Redevelopment of land at the former Rising Sun PH and the construction of 7no. new dwellings with associated landscaping and parking.

Land adjacent to The Rising Sun 351 Chichester Road Bognor Regis

Engineers Comments:

■ Enterprise Inns	■ Project	EIRSNB
■ Land at the Former Rising Sun PH, North Bersted	■ Ding Norton	PL-101
■ Existing Site Plan	■ Scale	1:200@A1
	■ Date	July 2012
	■ Checked by	CB

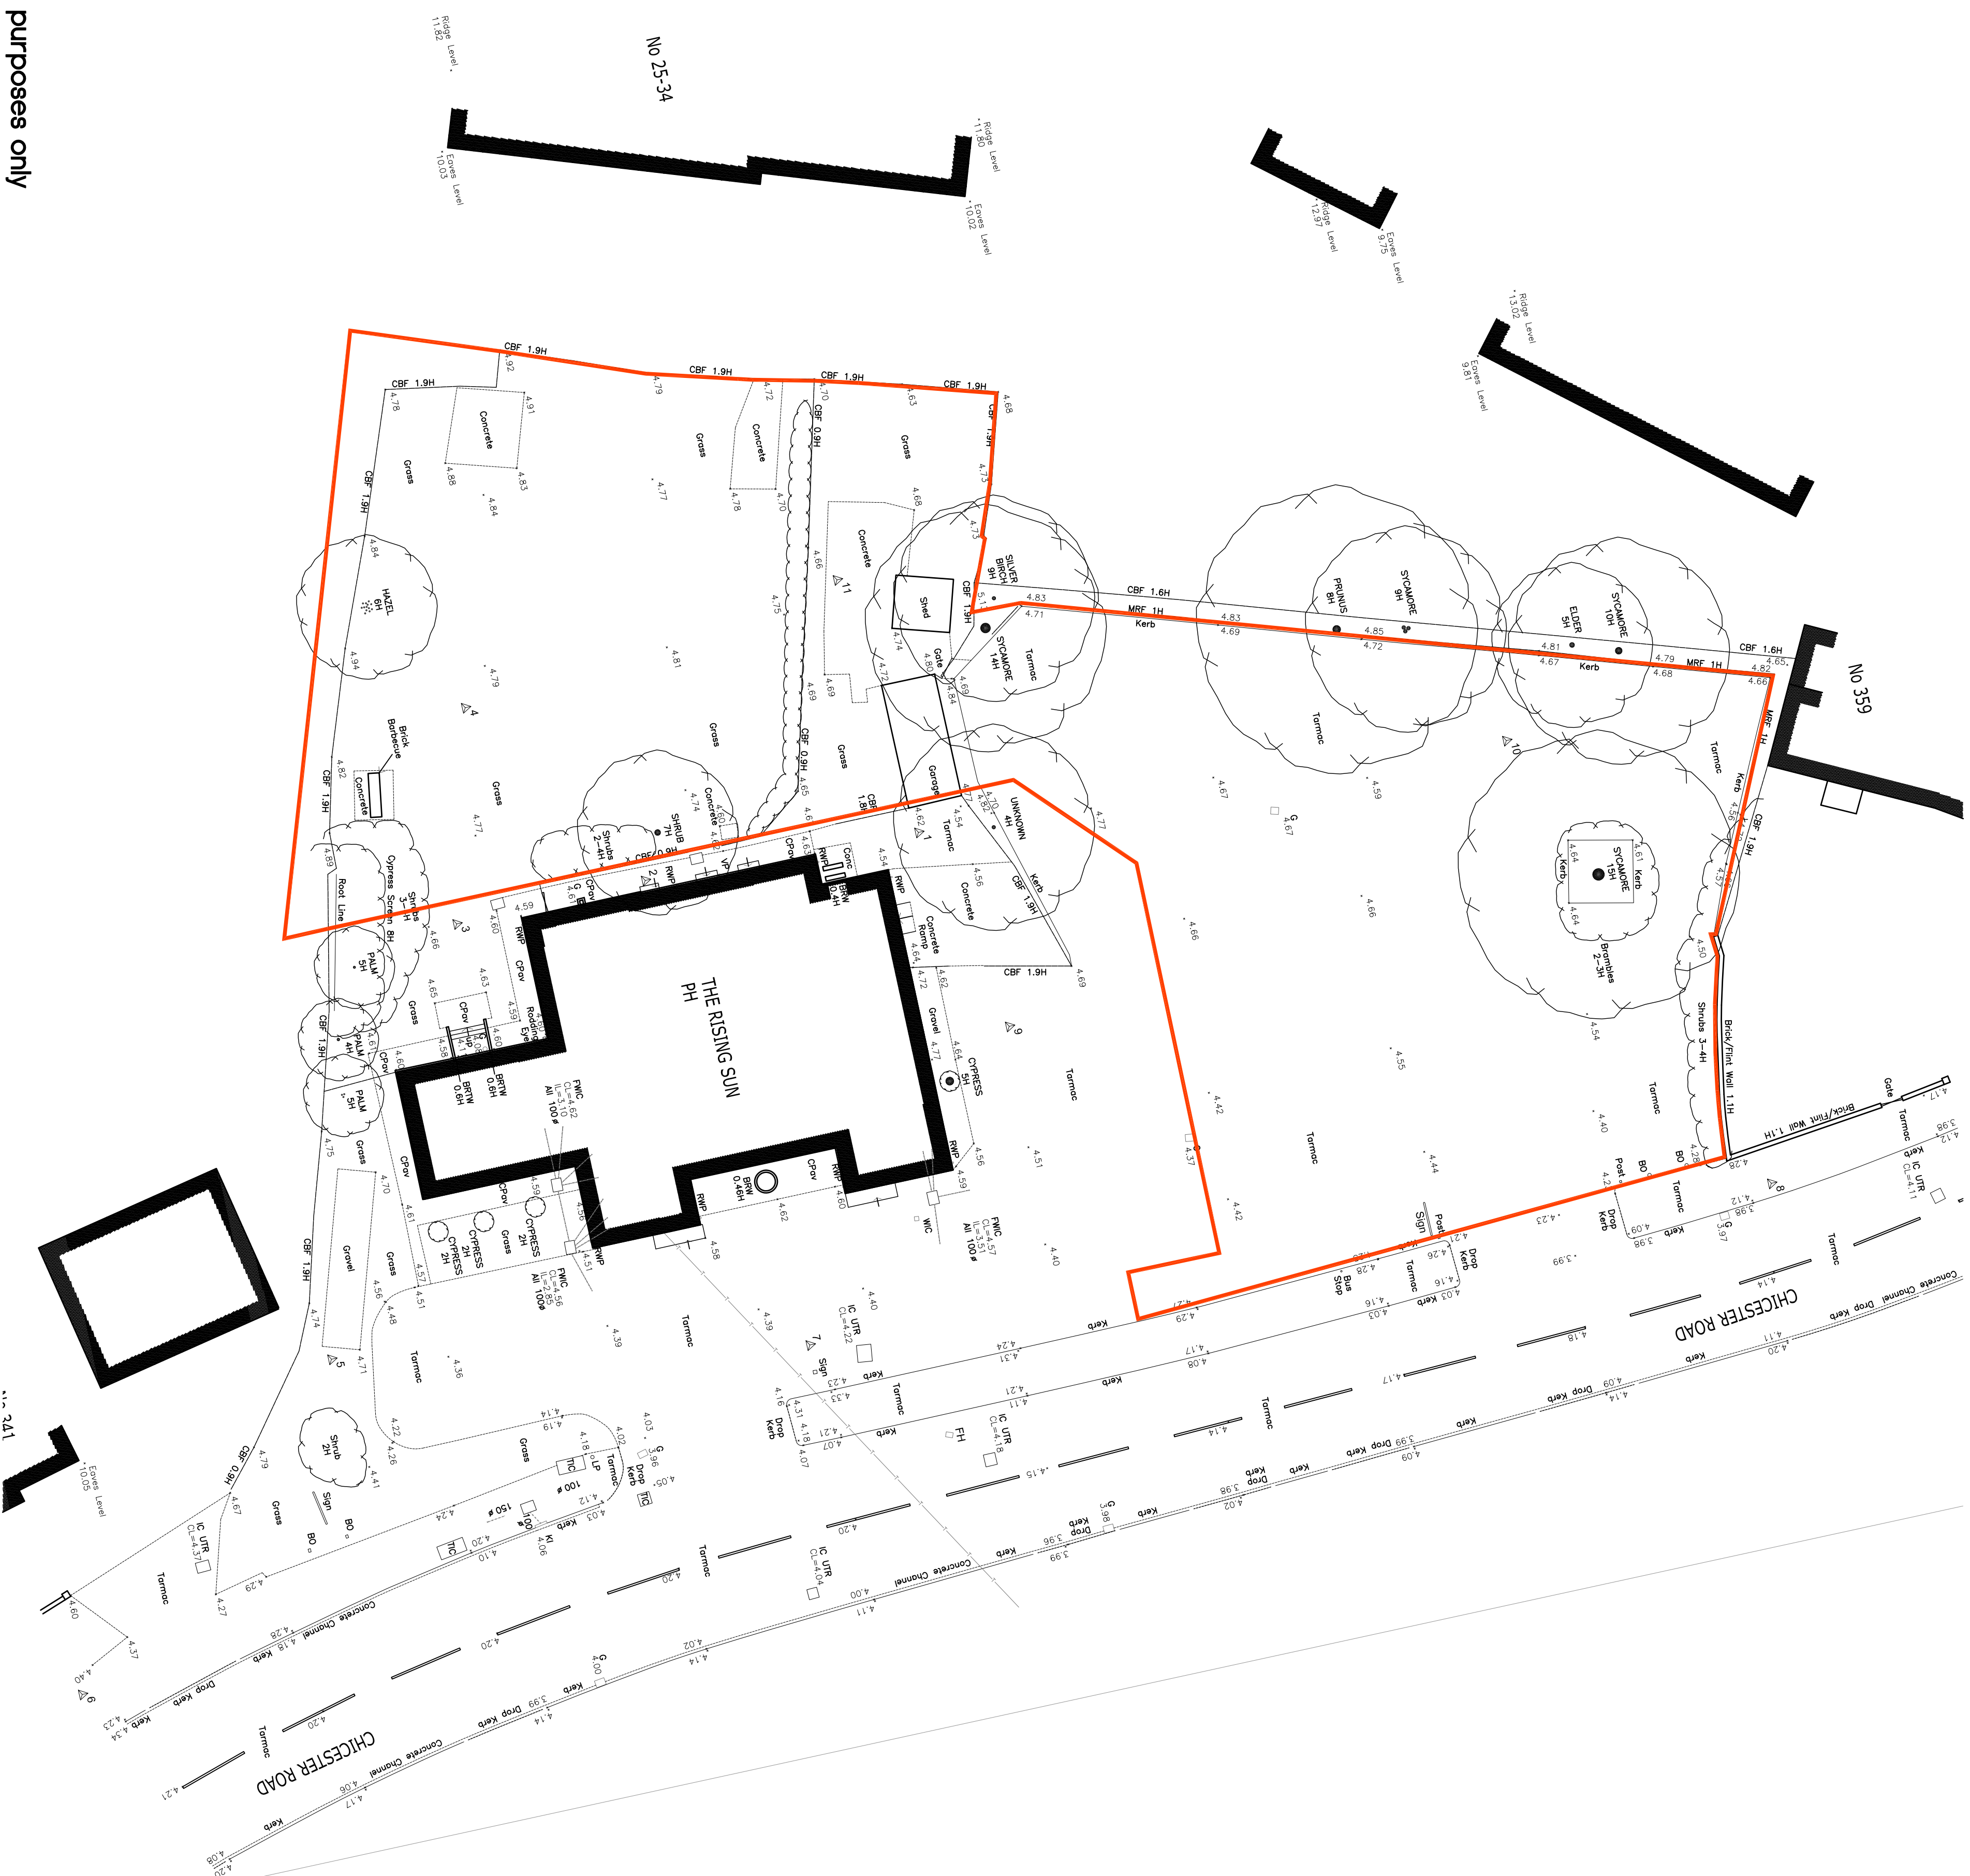
The applicant should be made aware of the presence of an open watercourse and culvert on the southern boundary of the development. Hence, the reason for condition ENGD6A.
